Subject: RE: Picture for Simon

PROJECT	THE POTTING BARN HOBBS COURT, BILSHAM ROAD YAPTON BN18 0JY		
DRAWING	HOUSE PLAN PROPOSED BOARDERED FENCE		
Date	June 2021	Drawn By	PJC
Scale	1: 100 @A3	Iss. App. By	DKC
Drawing No	023 A	File Location	0221

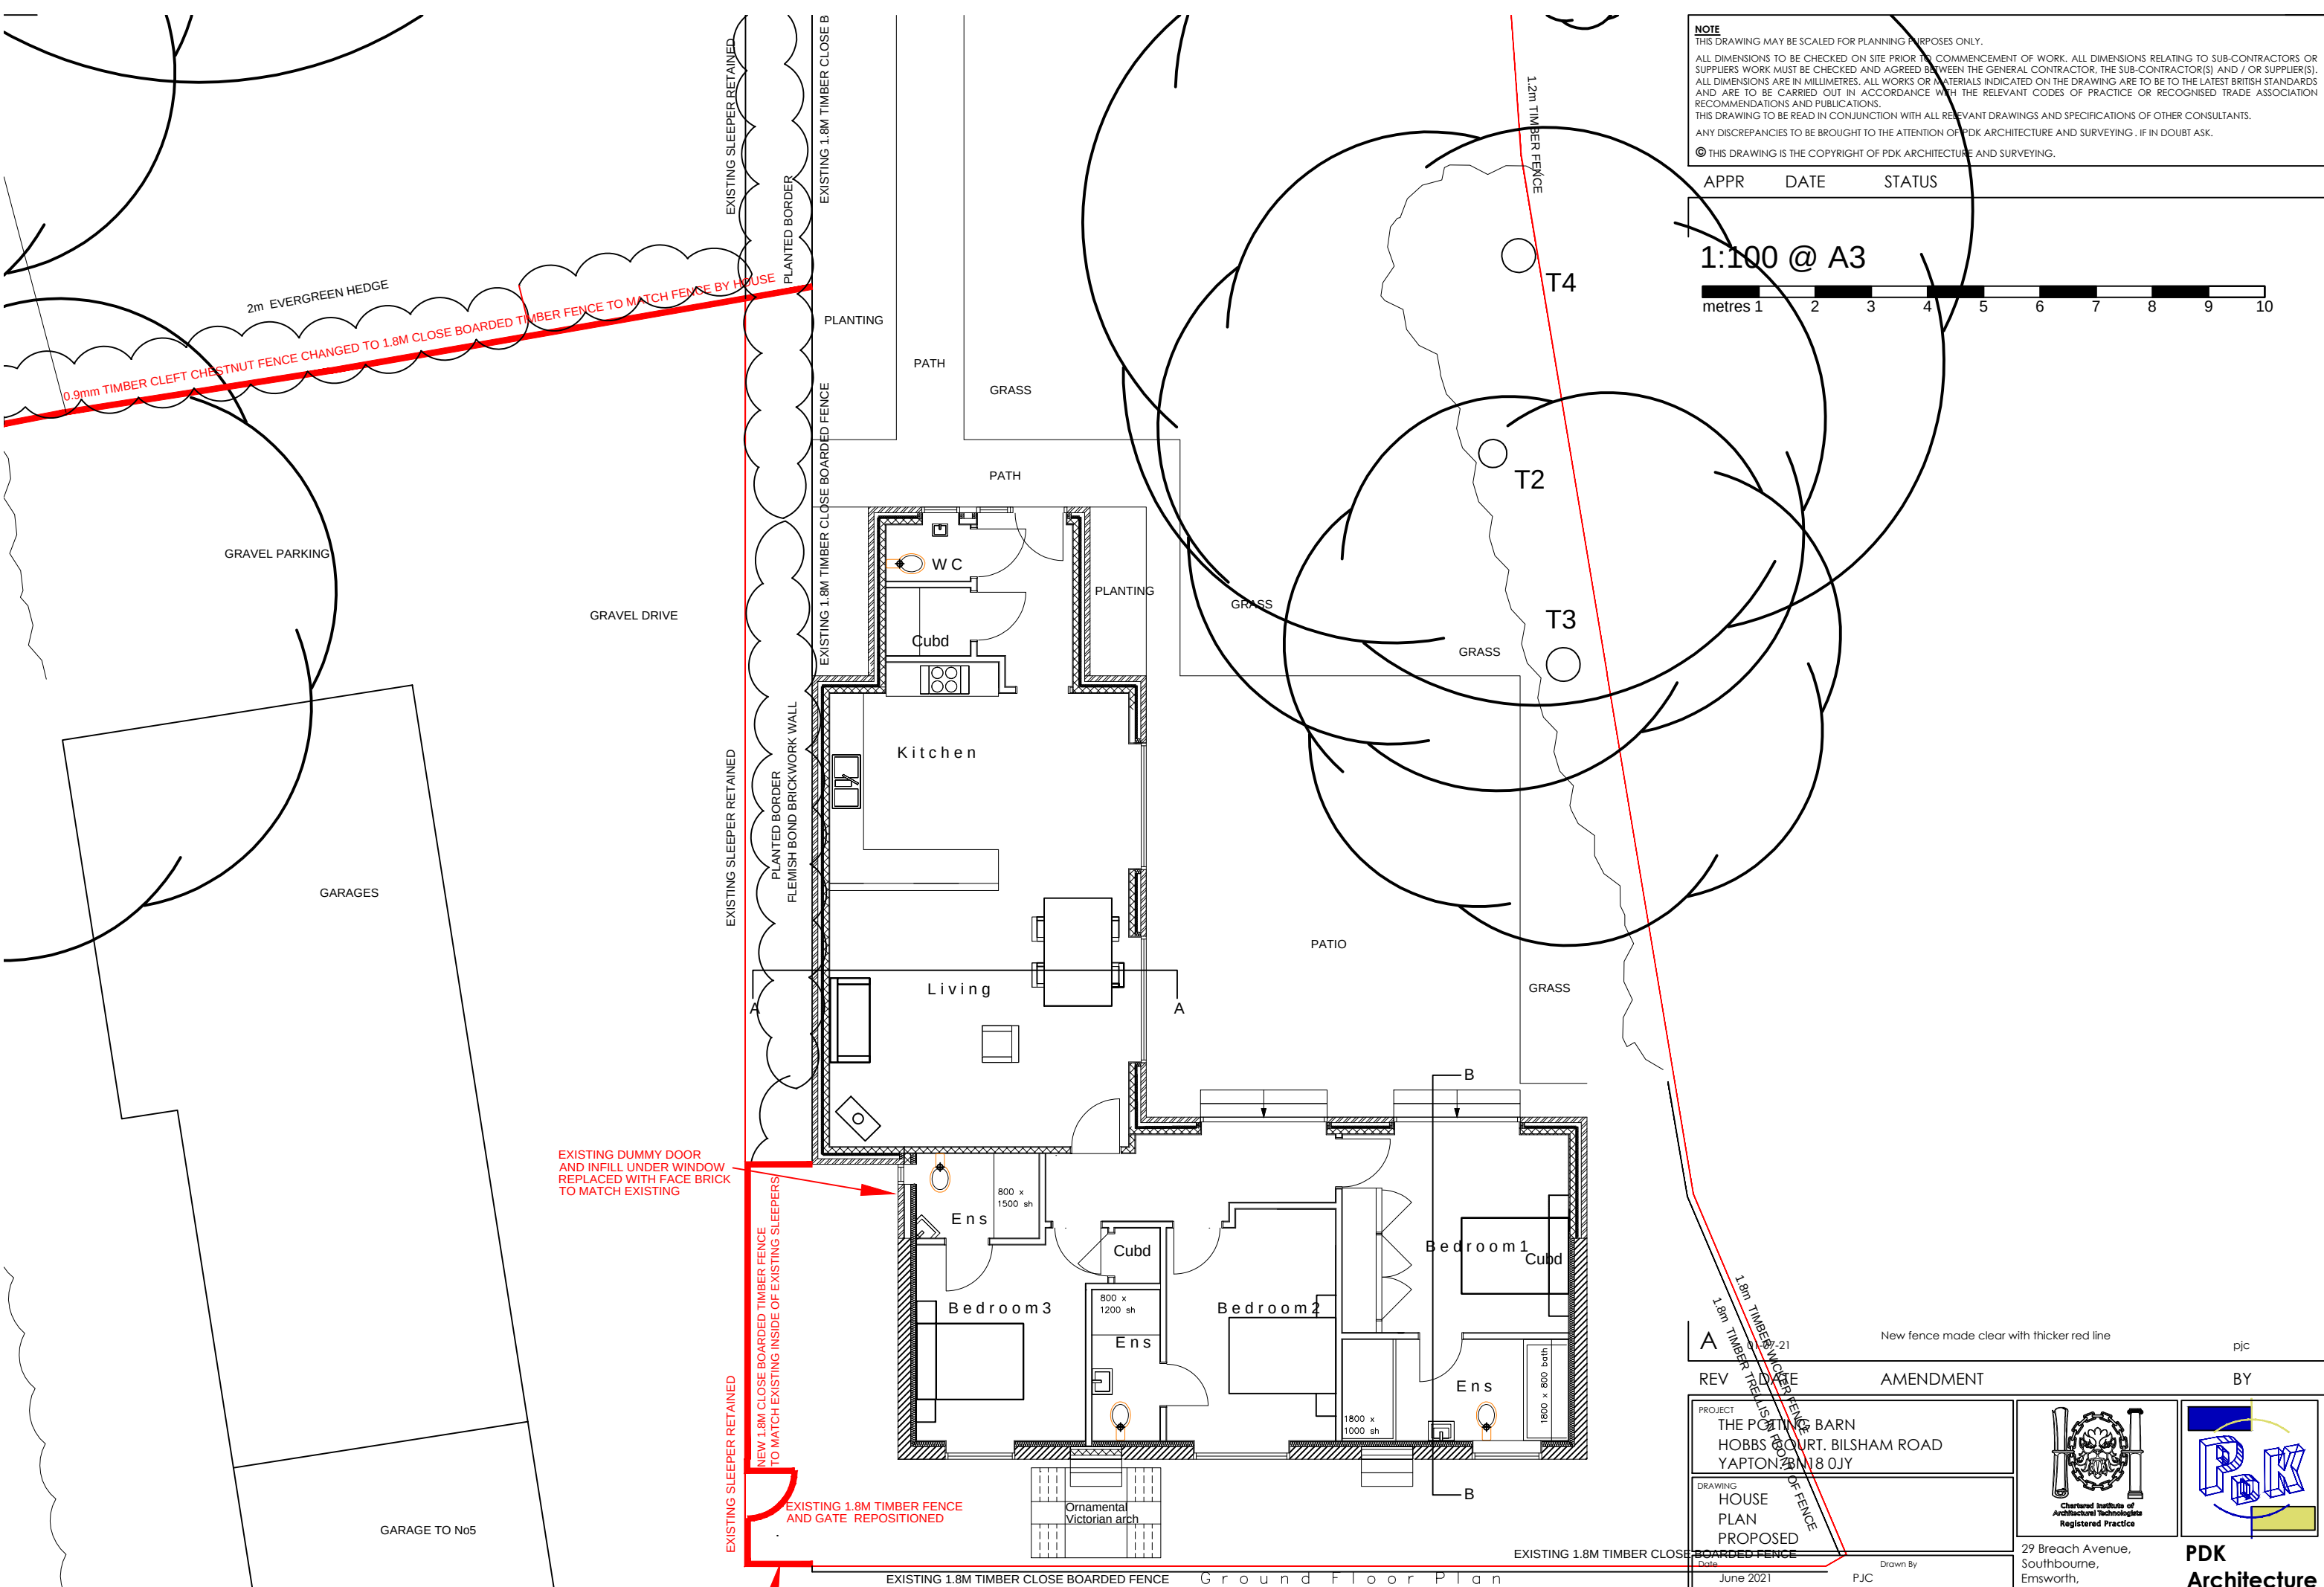
I don't think I have any concerns – although I can see that there is a difference in the style of fencing proposed on the boundary with the neighbouring property, which could look odd.
